Application No: EP/22/21/HH
Site Address: 15 The Plantation East Preston BN16 1LD
Description of works: Erection of rear extension and loft conversion with rear dormers and side gables

Thank you for your internet representation made on 23rd April 2021 which has been recorded as an objection with the comments as follows:

Plans & Elevations As Proposed

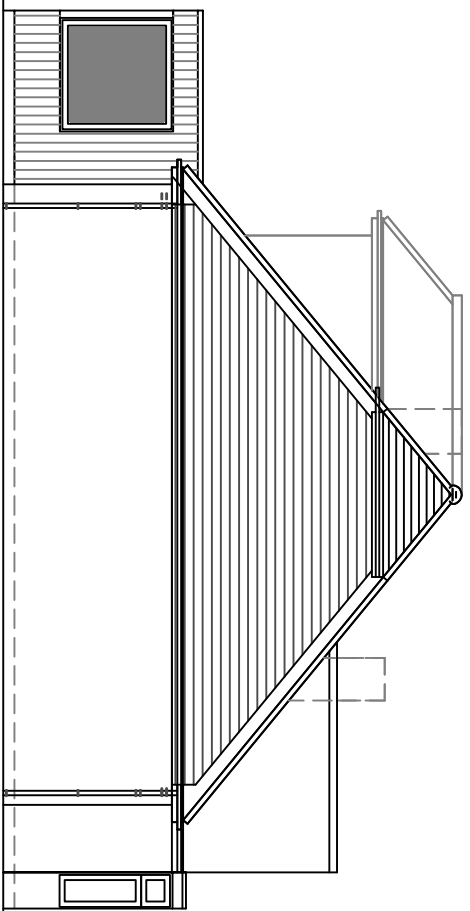
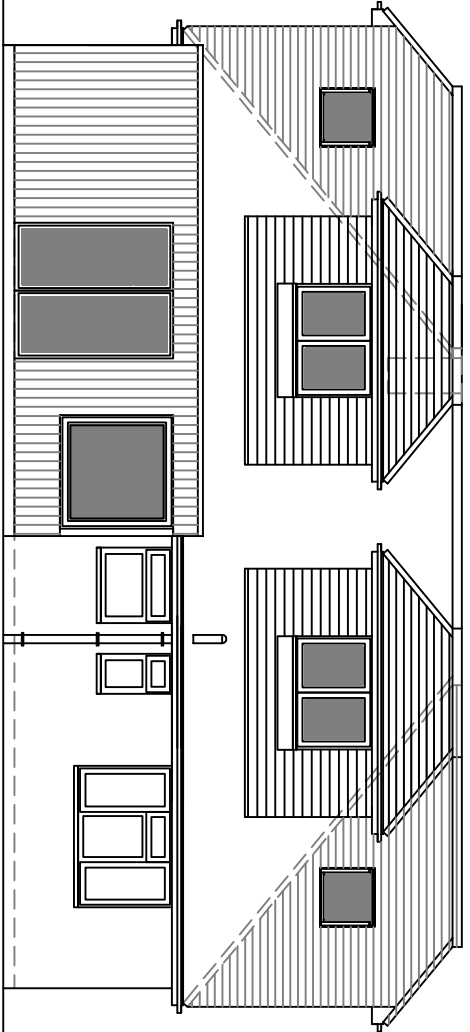
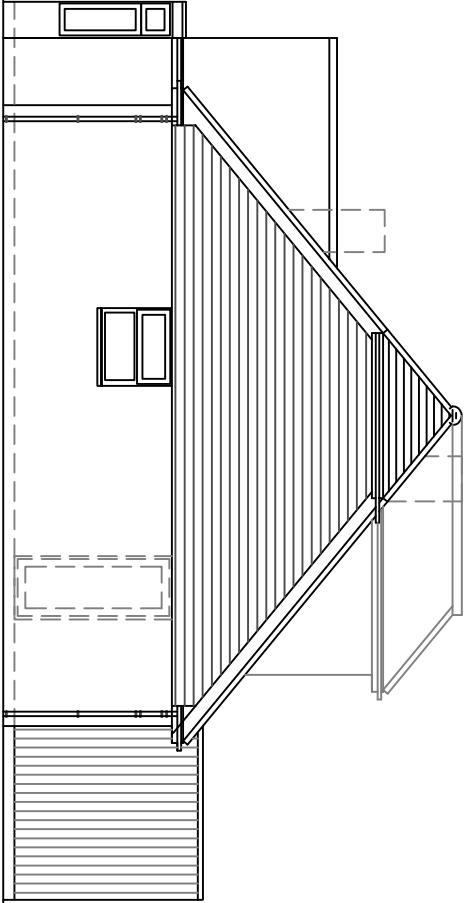
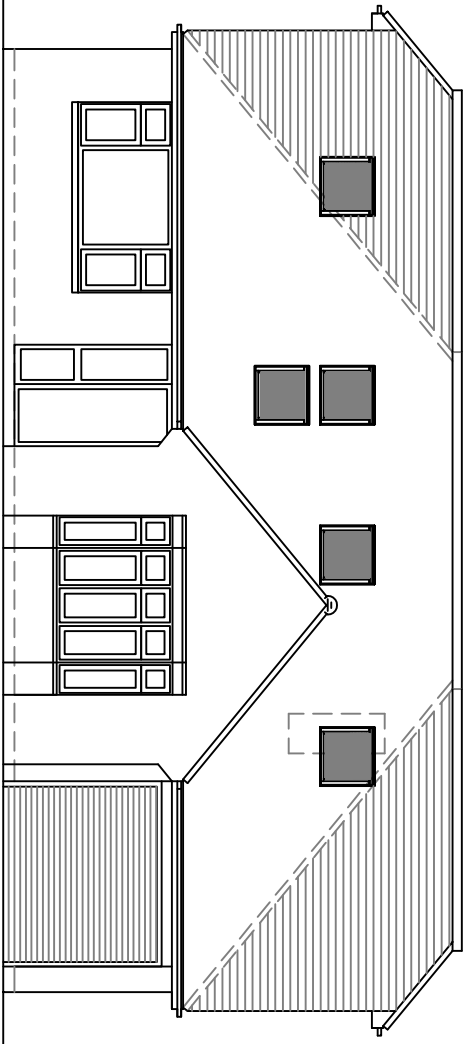
The proposed gable ends and extension in length of the ridge will make a large impact on the area and are out of keeping with the remainder of the surrounding properties. Various features are inconsistent with the recommendations of the Village Plan and, overall, this development will also be overbearing for immediate and close neighbours. We strongly urge the council to reject this application as presented.
